From: Michael Eastham <Michael.Eastham@arun.gov.uk>
Sent: 15 December 2020 13:46
To: Planning.Responses <Planning.Responses@arun.gov.uk>
Cc: Claire Potts <Claire.Potts@arun.gov.uk>
Subject: FW: A/166/20/DOC - Manor Nursery, High Street, Angmering

Please upload onto Ocella the email below from the **Local Highway Authority** raising no objection to the approval of **Condition 6** of discharge of condition application **A/166/20/DOC** relating to Manor Nursery, High Street, Angmering.

"The following information submitted regarding Condition 6 imposed on the outline planning permission A/51/14/OUT: relating to the prevention of surface water draining onto the public highway is approved and the condition is hereby discharged.

CLIENT	Roffey Homes Ltd		
PROJECT	Manor Nurseries Site Angmering		
TITLE	Proposed Drainage Strategy		
DRAWN	DATE	PROJECT NO.	
T Zajac	Mar 2018	22995	
ENGINEER	CHECKED	DWG. NO.	REV.
S Magowan		102	D
SCALE	1:250 @ A1

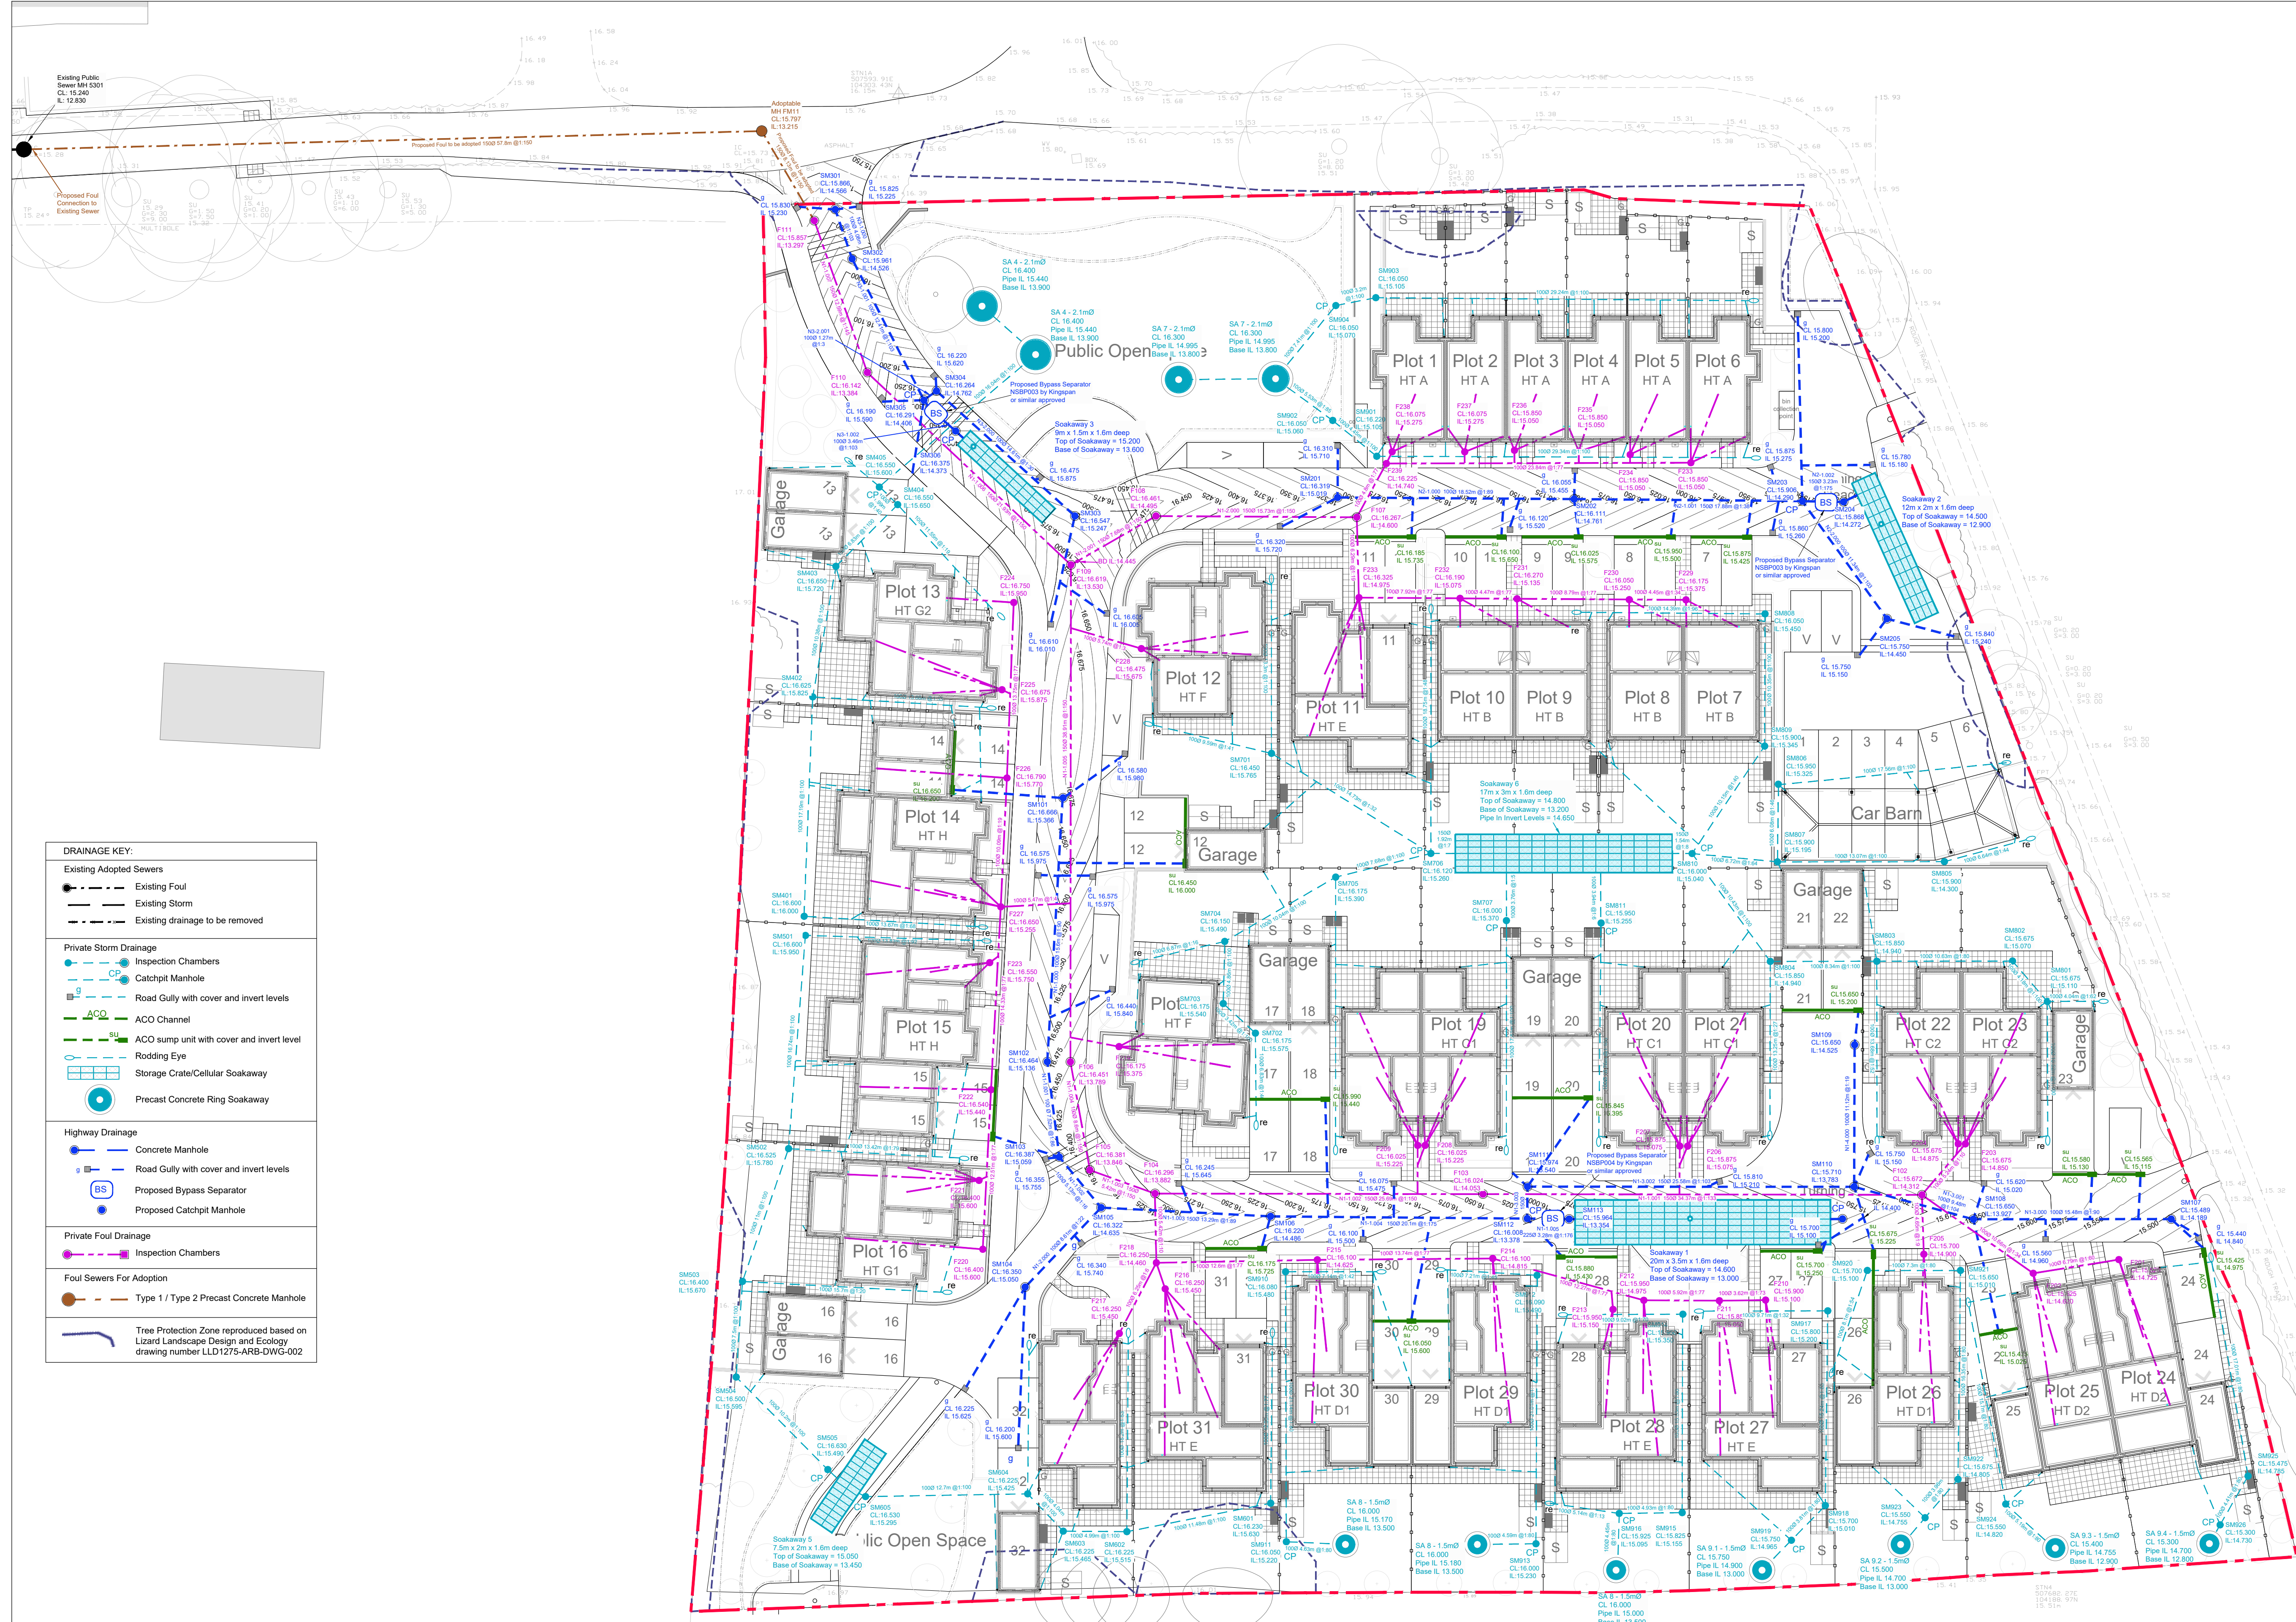
Hello Michael, regarding condition 6, quite a number of the documents listed below perhaps aren't relevant to this condition. I've certainly not been through all of them nor would given the requirement of condition 6. The one plan that does appear relevant is drawing No. 102 Rev. D - Proposed Drainage Strategy. Without knowing what the applicant's intention is for the on-site roads and whether these are to be adopted as public highway or not, this plan at least indicates drainage at the junction of the public highway and development access road as well as at the numerous domestic accesses within the site. Effectively all bases are covered with the drainage shown on this plan. My recommendation would be for condition 6 to be discharged based on the Proposed Drainage Strategy plan only.
